**Consultation Response from KC,
Lead Local Flood Authority**

2023/93342 Moss View, Burnlee Road, Holmfirth, HD9 2LE

Outline application for demolition of existing dwelling and garage and erection of two detached dwellings with attached garages

Date Responded: 25th February 2024

SITE PLAN (1:200)

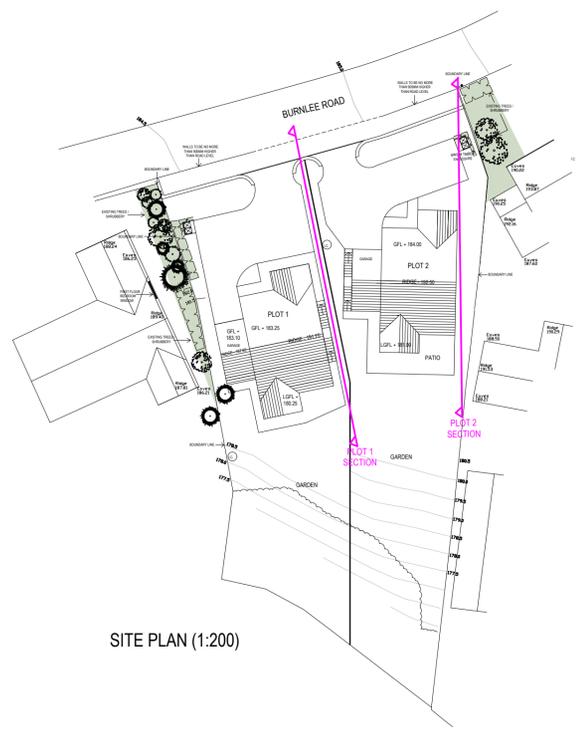
Our records show the possibility of a watercourse entering site from the north at the eastern boundary. A second possible watercourse adjacent to the western boundary is suggested by a linear pattern shown on first generation surface water flood risk mapping.

We note a manhole is shown well away from the current property but within the curtilage. We recommend a full survey of site drainage, unknown manholes and associated pipework prior to any investigative trench work. Areas showing positive drainage need to be clearly indicated for an assessment of whether attenuation is needed, or grey water recycling is required to offset an increase in discharge to location sewers and/or watercourses.

Please note that watercourse will require stand off distances and could result in objections to the current layout.

A potential drainage scheme needs to be devised to demonstrate what is feasible on site. We would object to the pumping of surface water for this application.
